Site: Chalcroft Nursery Chalcroft Lane Bersted PO21 5TS

Proposal: Application under S96A for a non-material amendment to BE/26/24/RES to revise the window and roller shutter doors locations on the units and adjust the parking layout to suit.

Drawing Title Units 3, 4, 5 & 6 Elevations

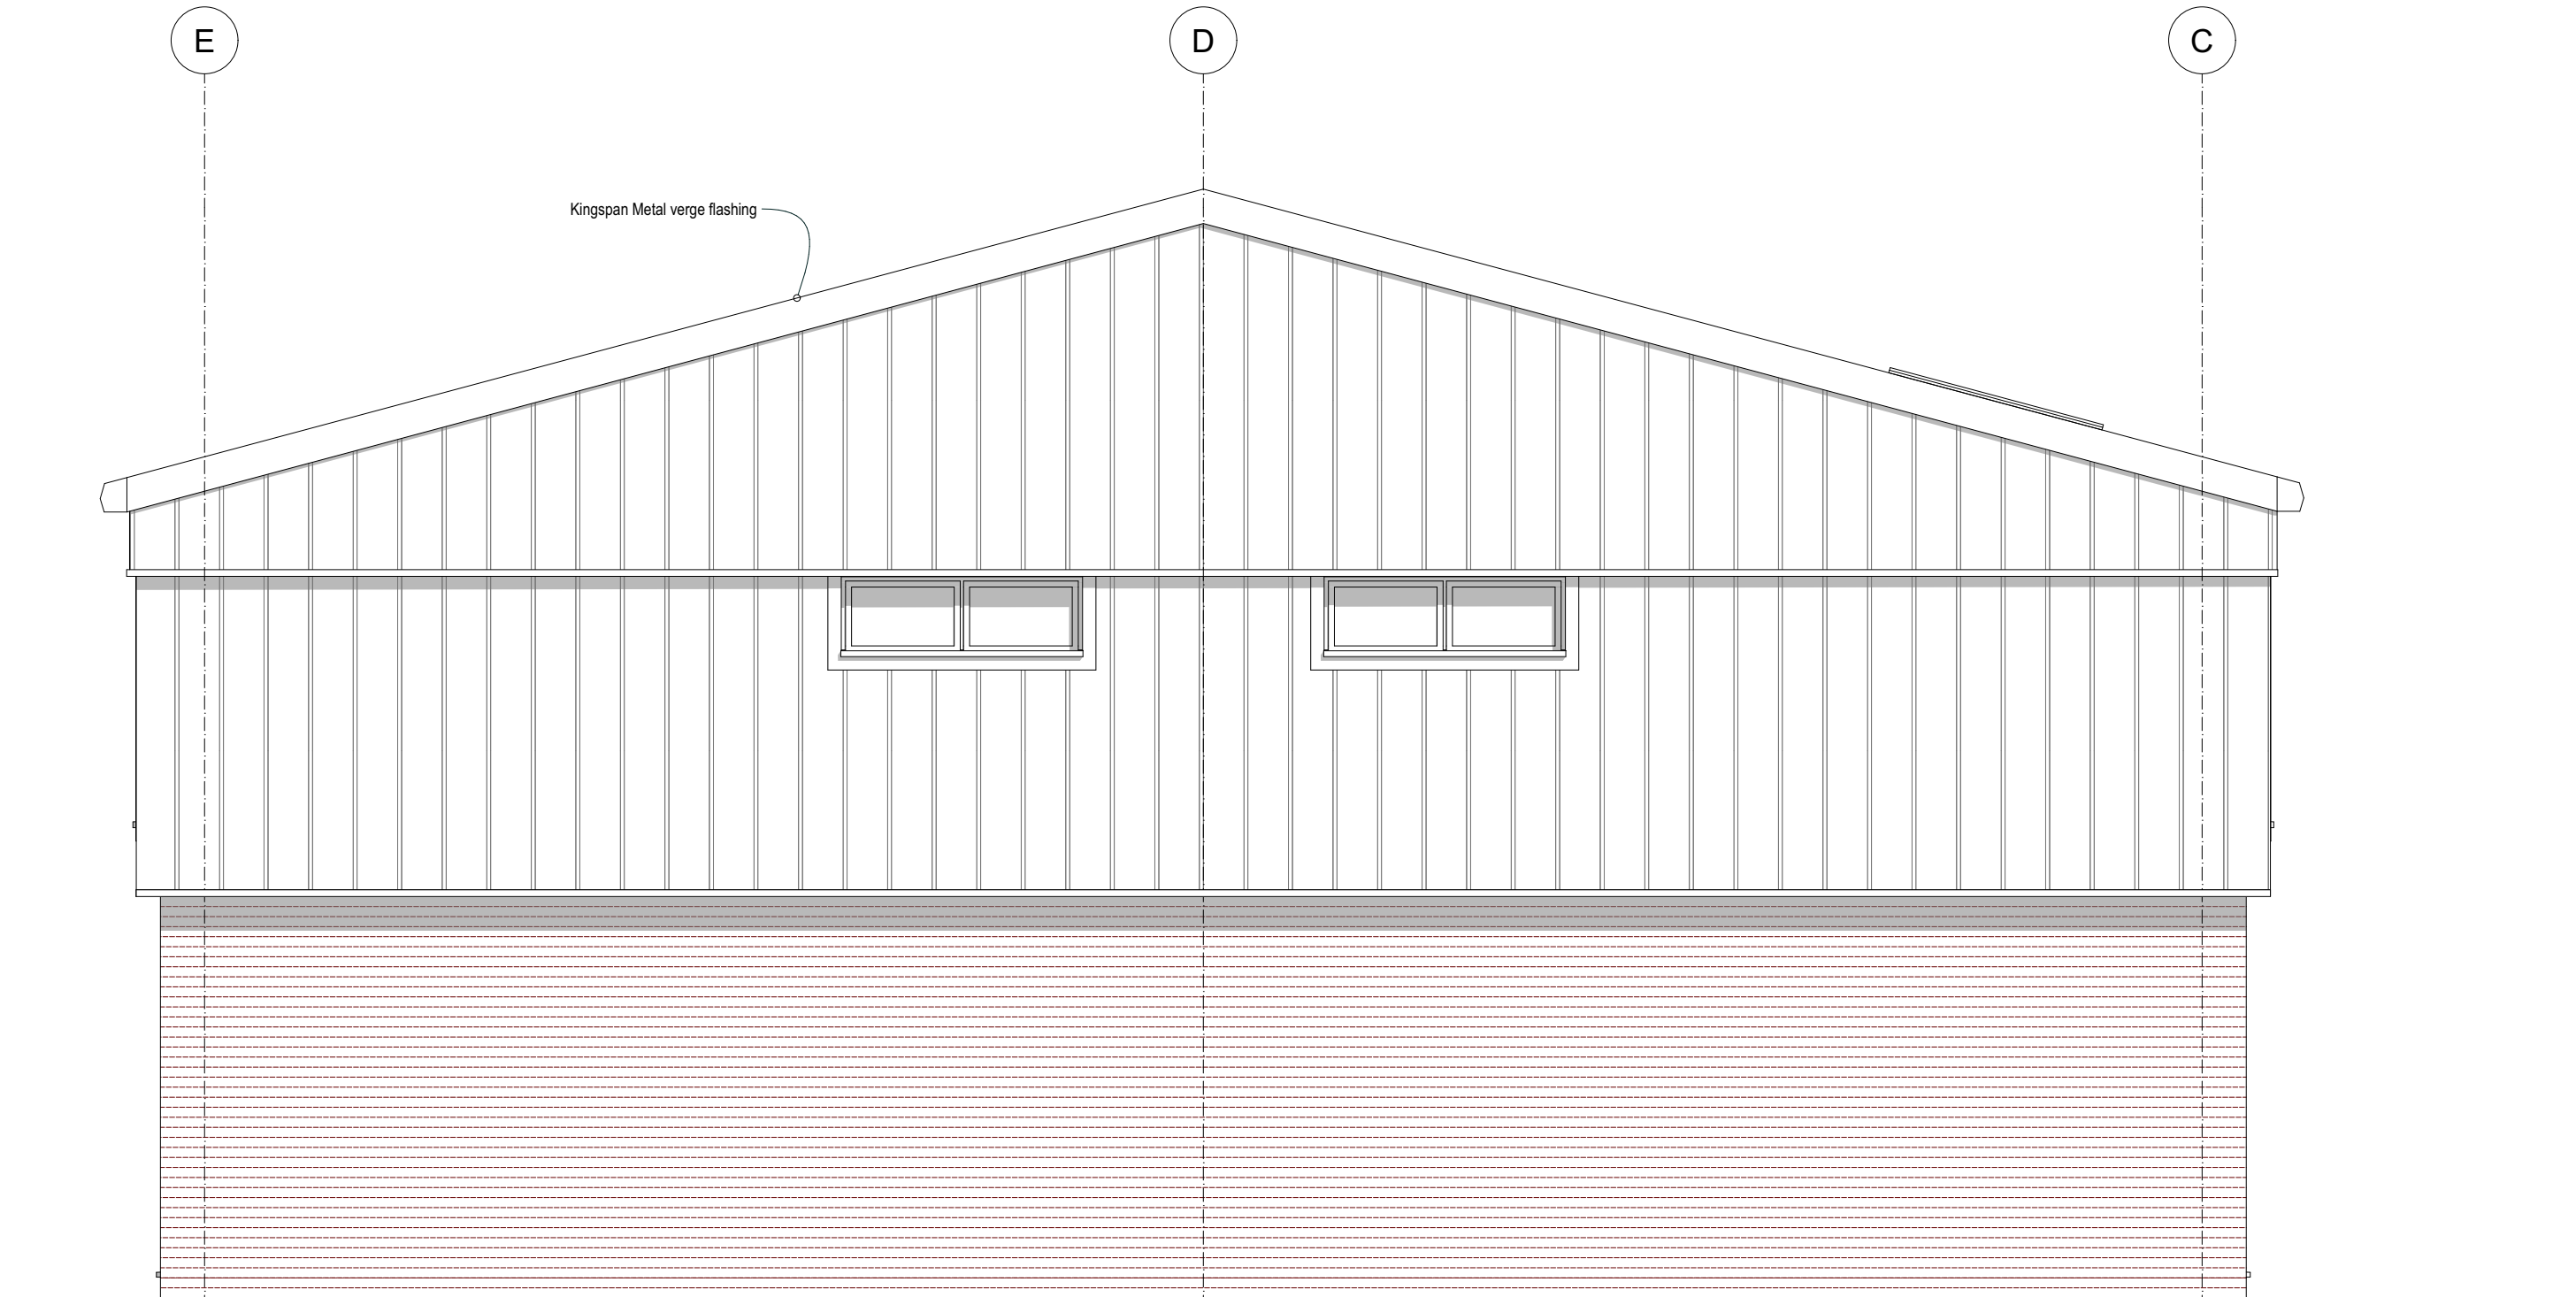
Since the application was approved, detailed drawings have been prepared for the discharge of conditions and building regulations approval. It has become apparent that the external personnel doors have to be relocated to allow for an appropriate relationship with the internal staircase to comply with building regulations. It is therefore necessary to swap the personnel door with the roller shutter doors on each unit and relocate the fenestration as a result. It is also necessary to reposition the parking spaces to allow access to the relocated roller shutter doors. The number of parking spaces remains the same.

New drawings of the units have been prepared to show the elevational changes along with a layout plan showing the repositioned parking spaces. A table setting out the approved and proposed amended drawings is set out below:
